GATEWAY 36, BARNDSLEY
ROCKINGHAM - PHASE 2B

UNIT 7

MITIGATION MEASURES

Response to XQLA Landscape Review - rev. B

**Site Sectional Elevations - rev. A**

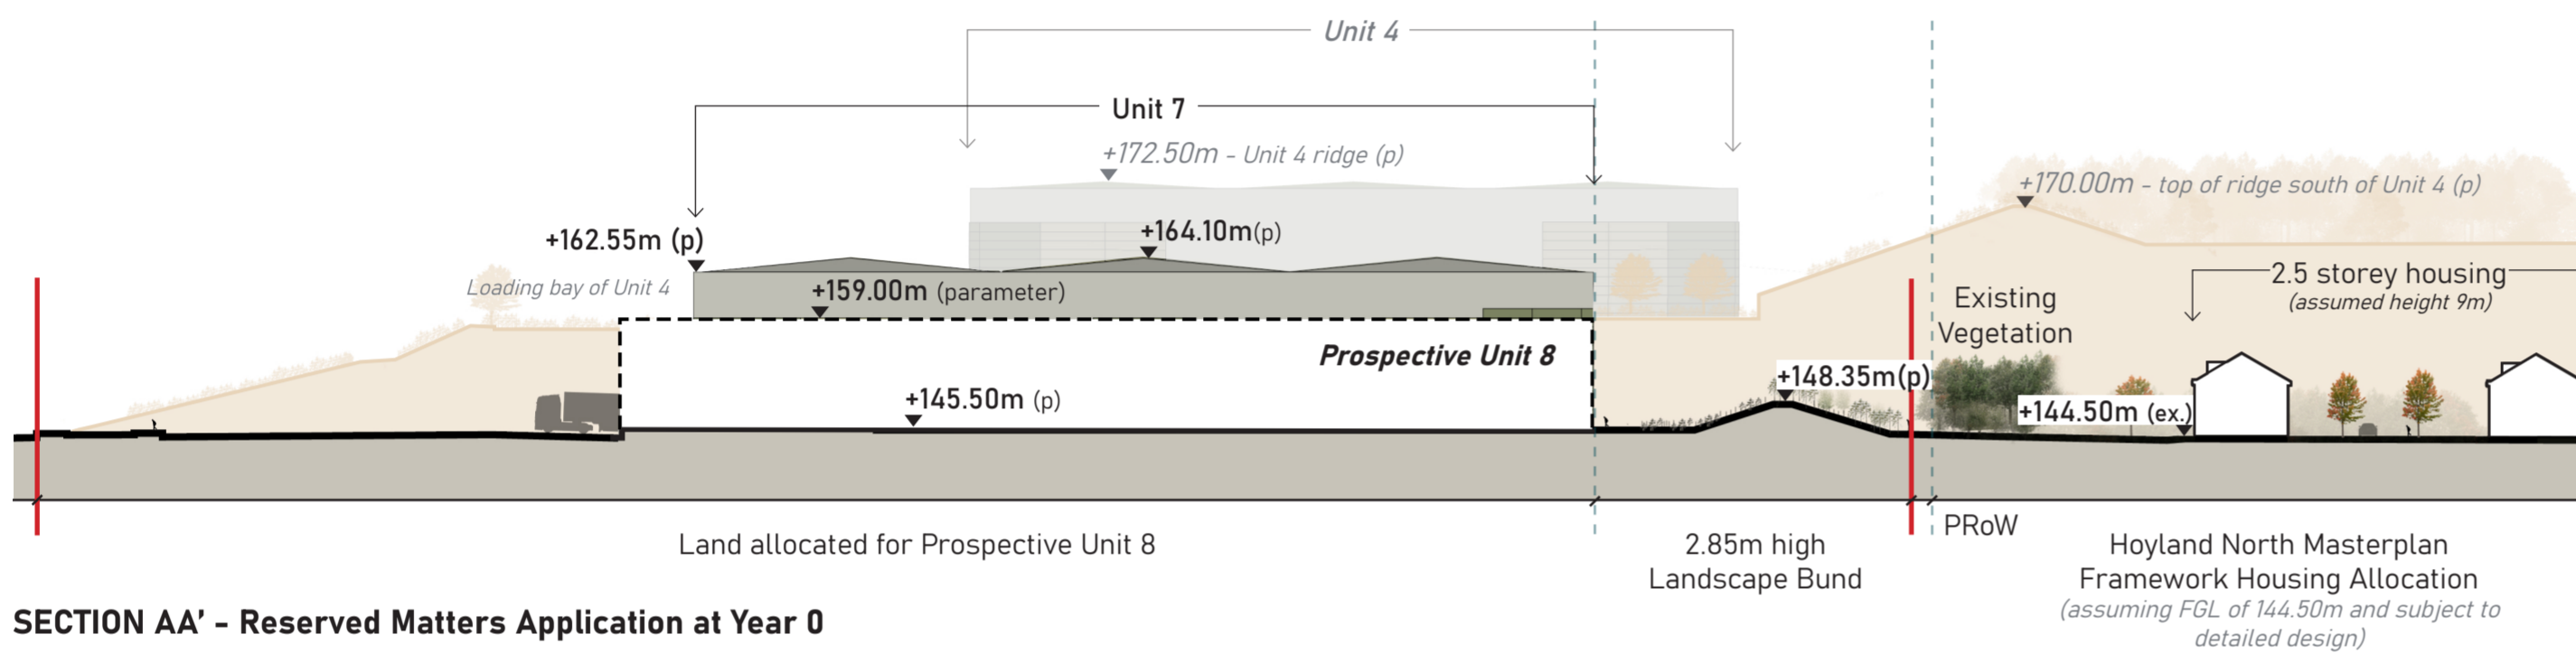
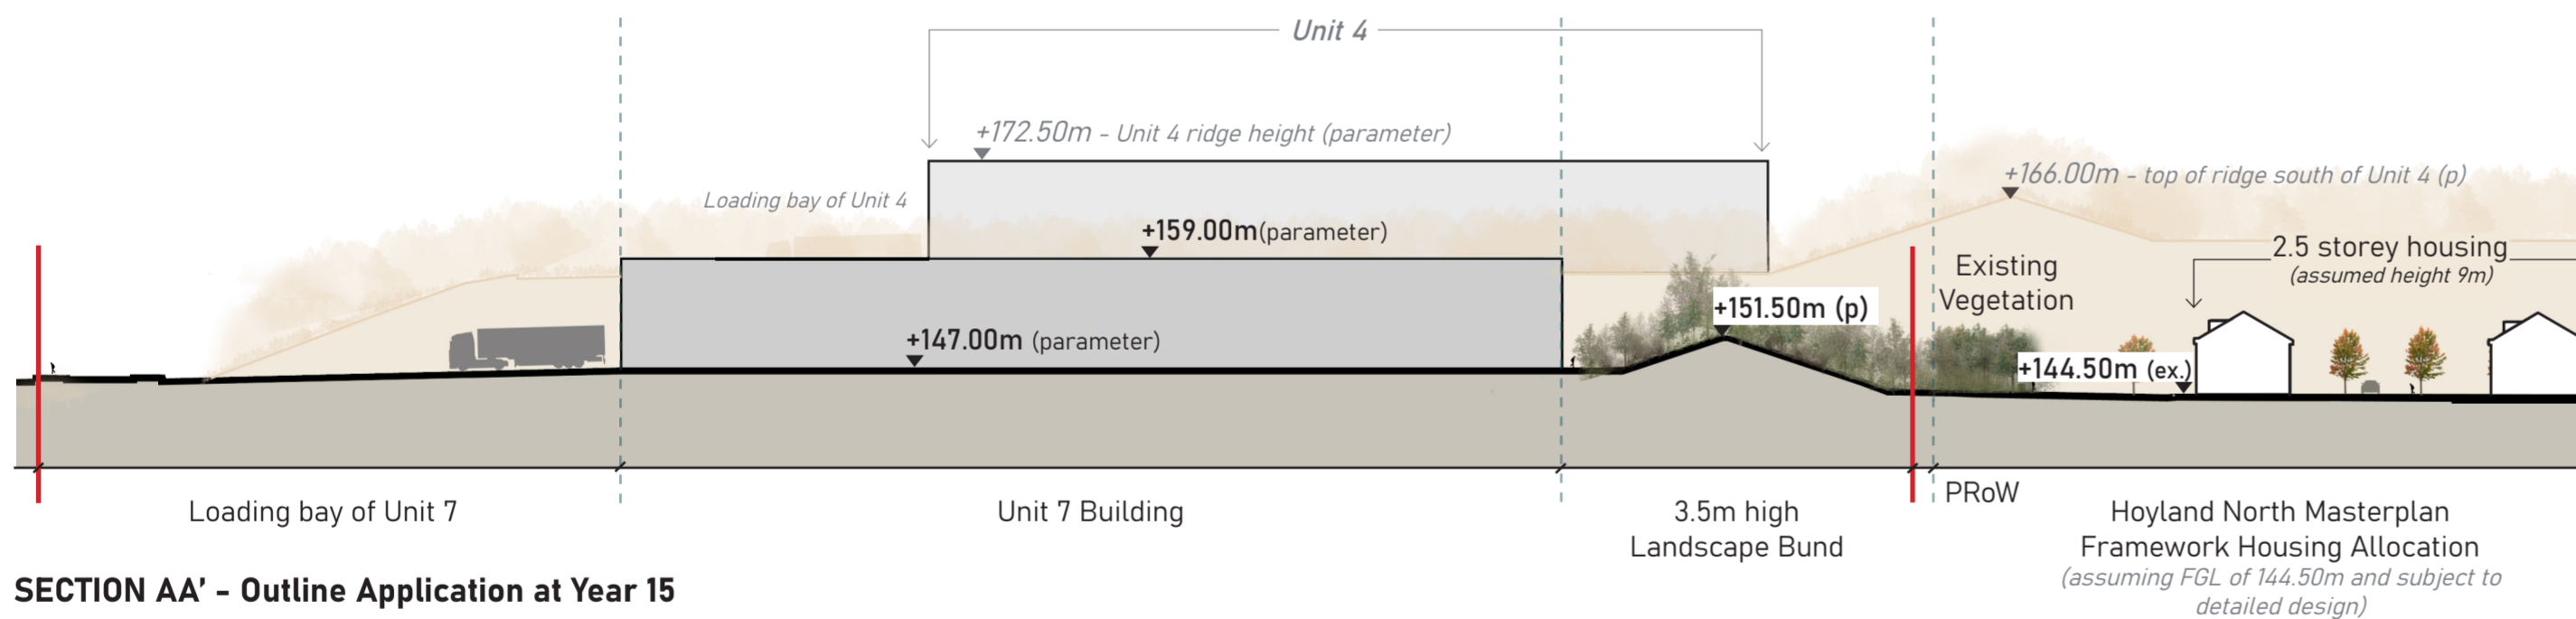
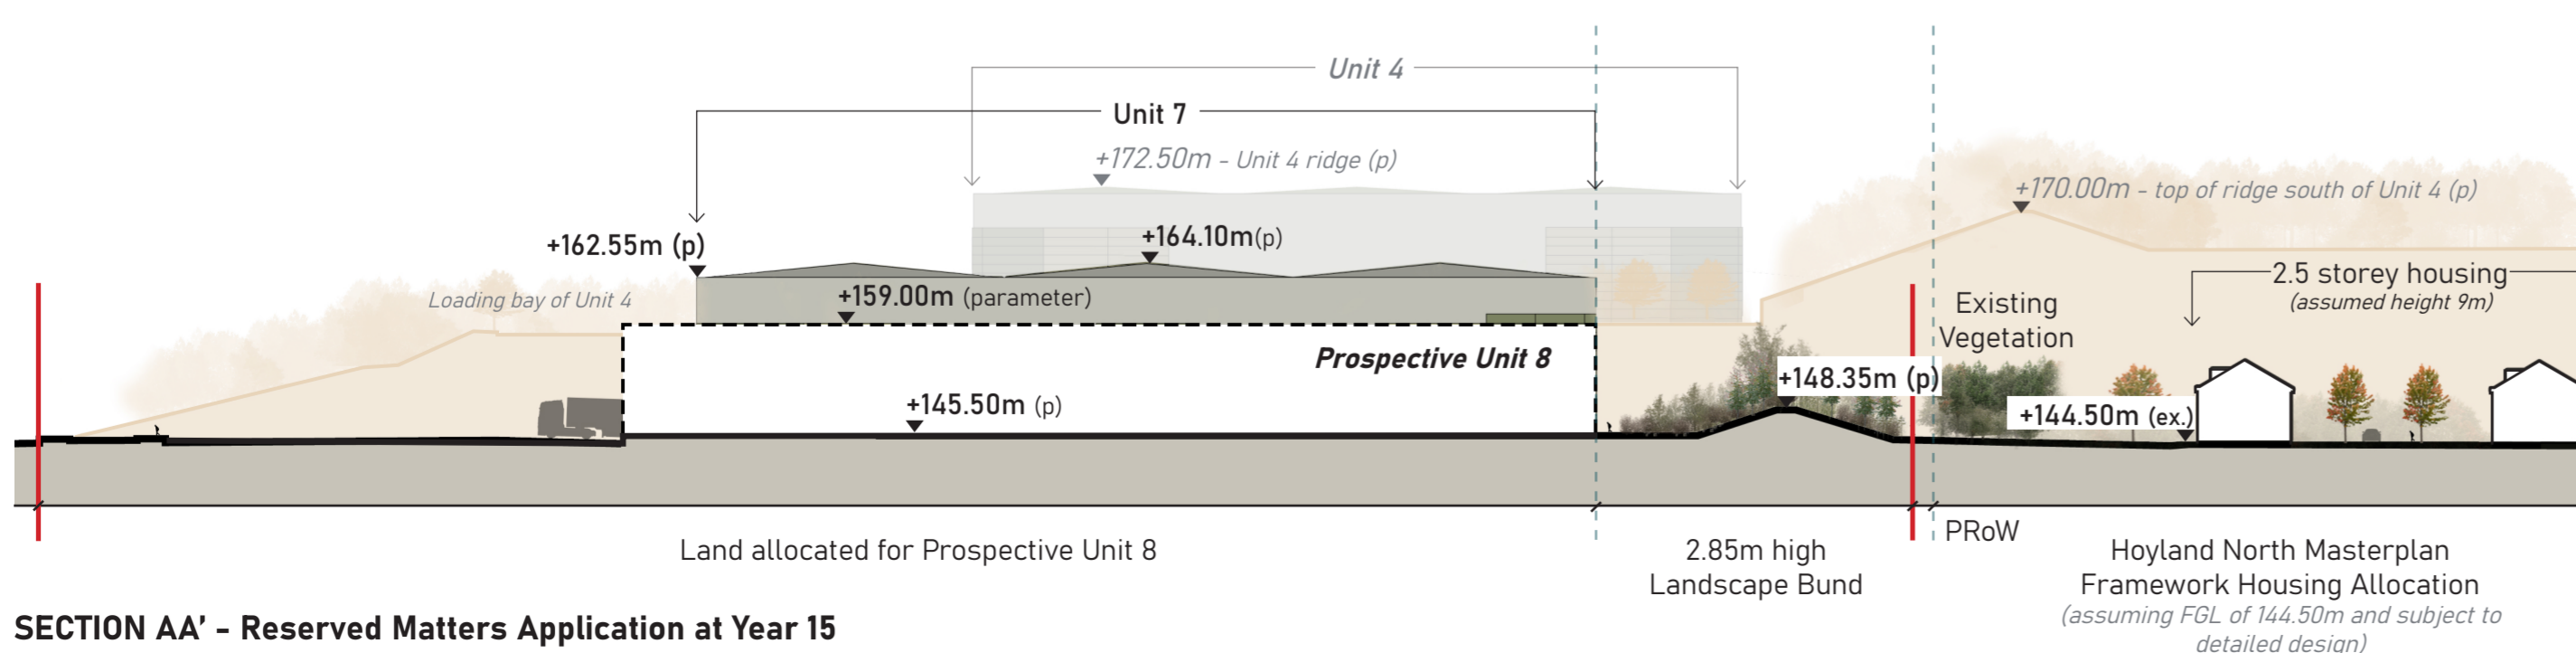
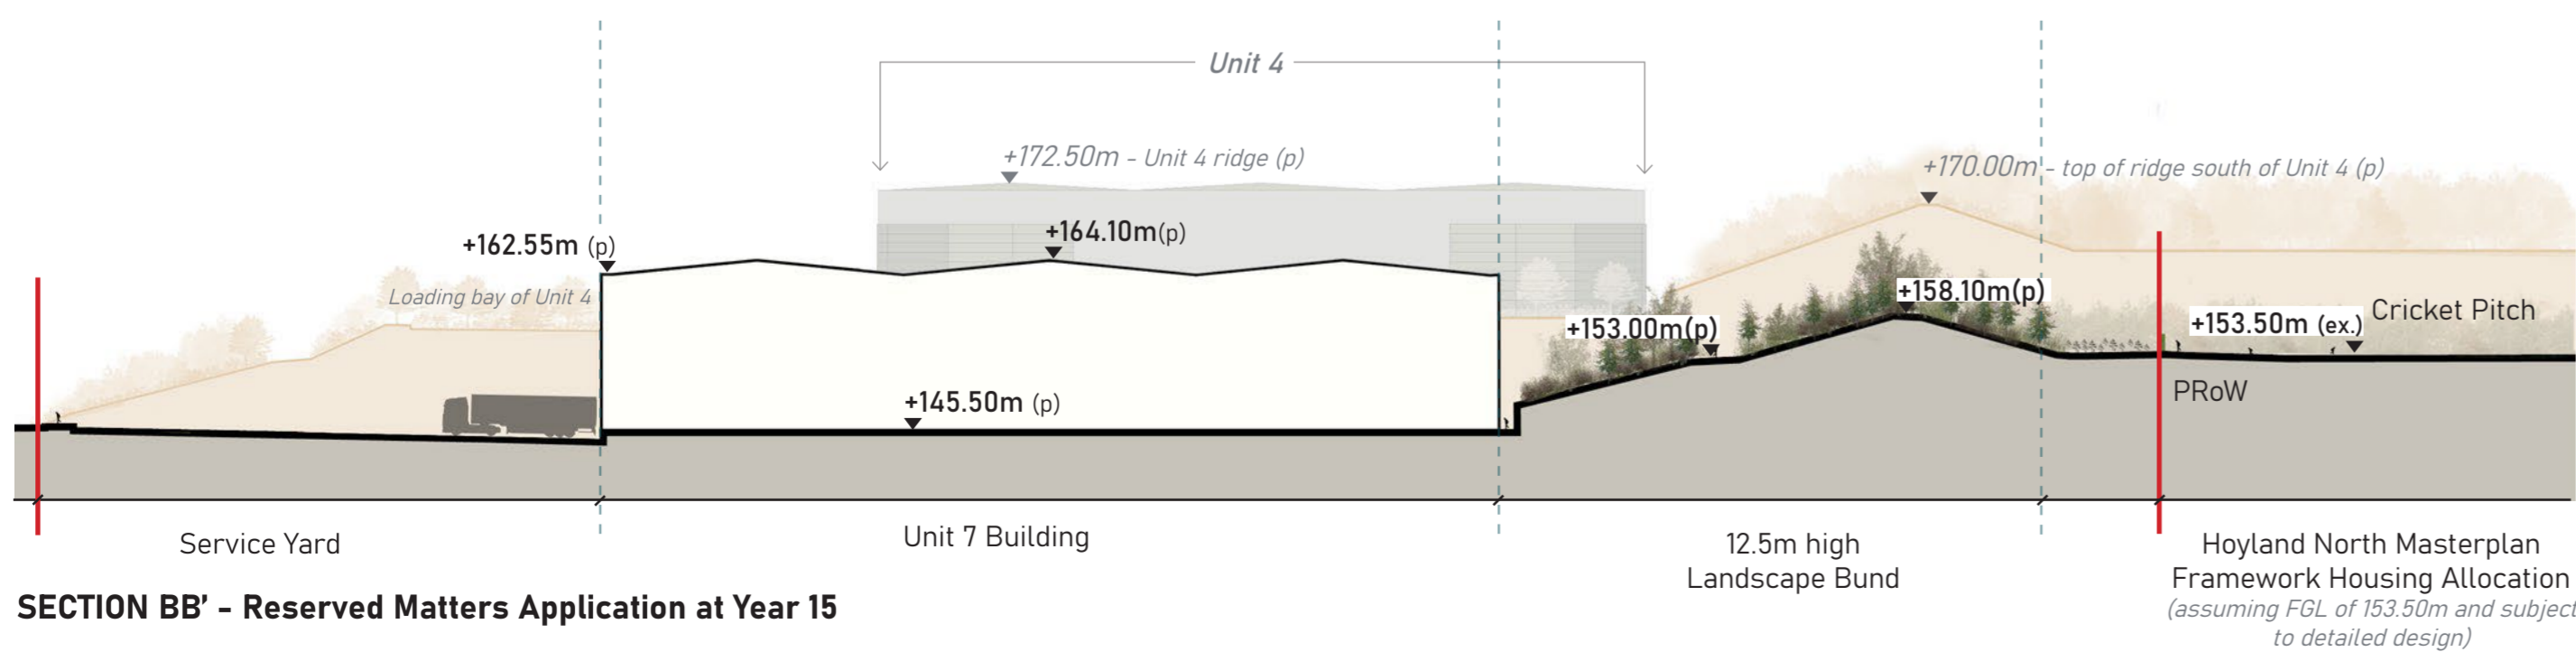
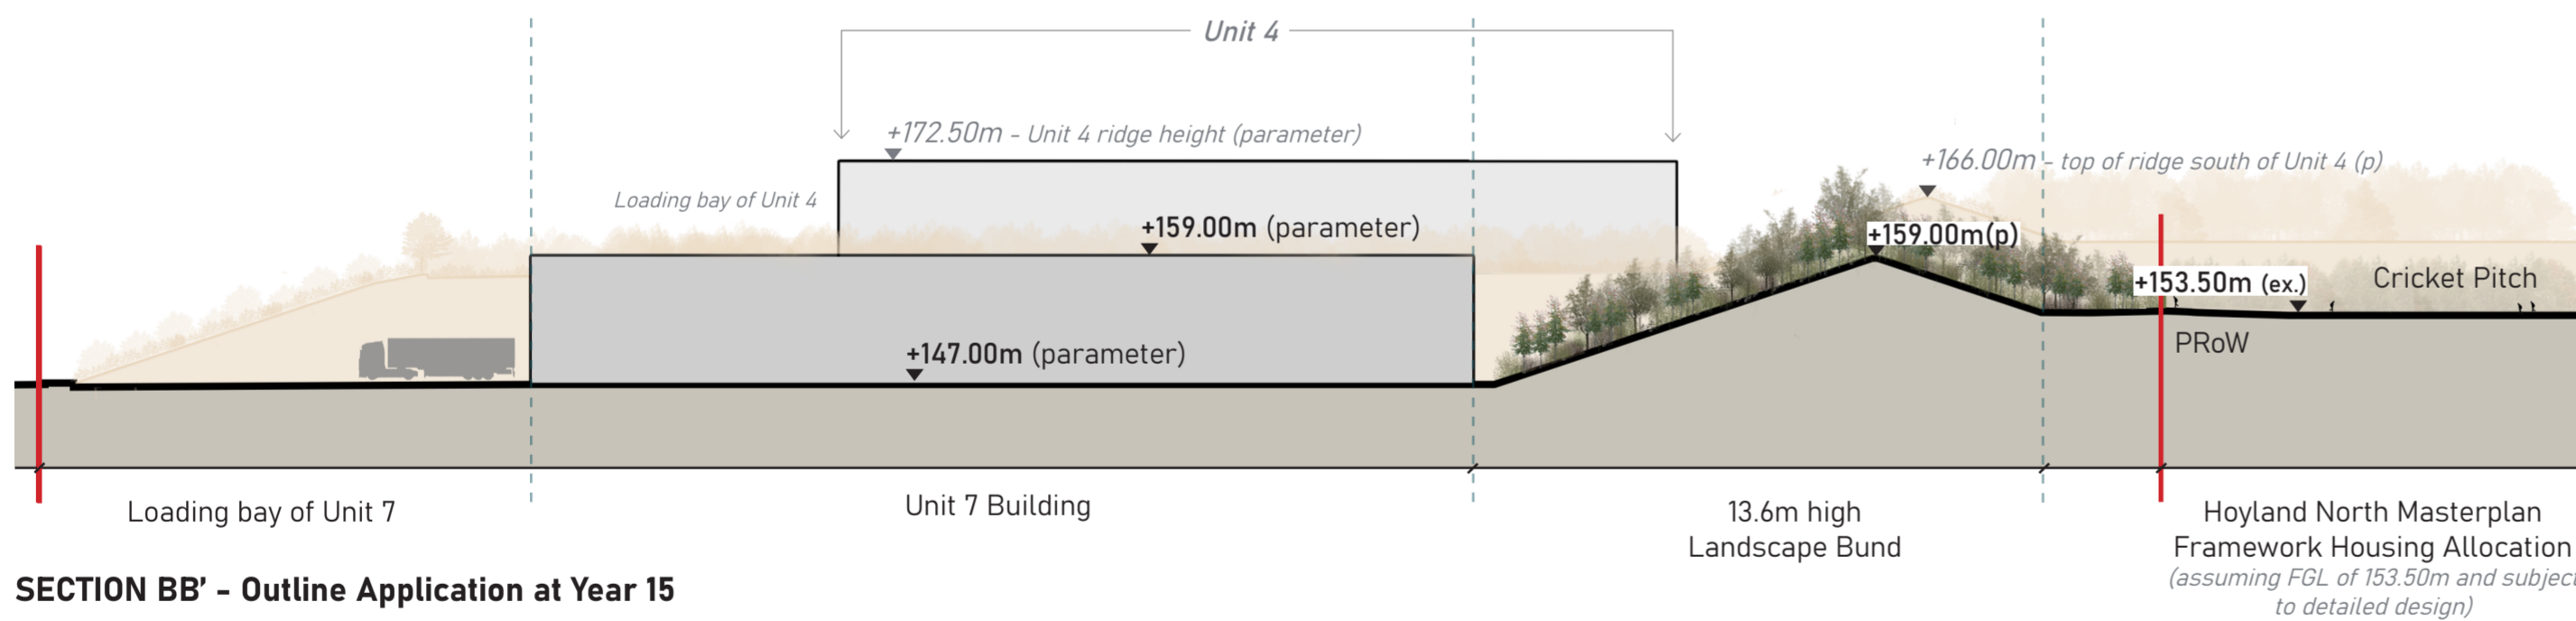
- The variation in bund height has been illustrated in **Fig. 4** using schematic sections.
- The ridge height, 12.6m (158.1m - 145.5m) represents the maximum height achievable considering both the structural stability of the mound and existing embankment (at 1:3 slope), available on-site surcharge material and the constraints of space to the rear of Unit 7.

- Therefore, there is no scope to increase the height of the bund further.
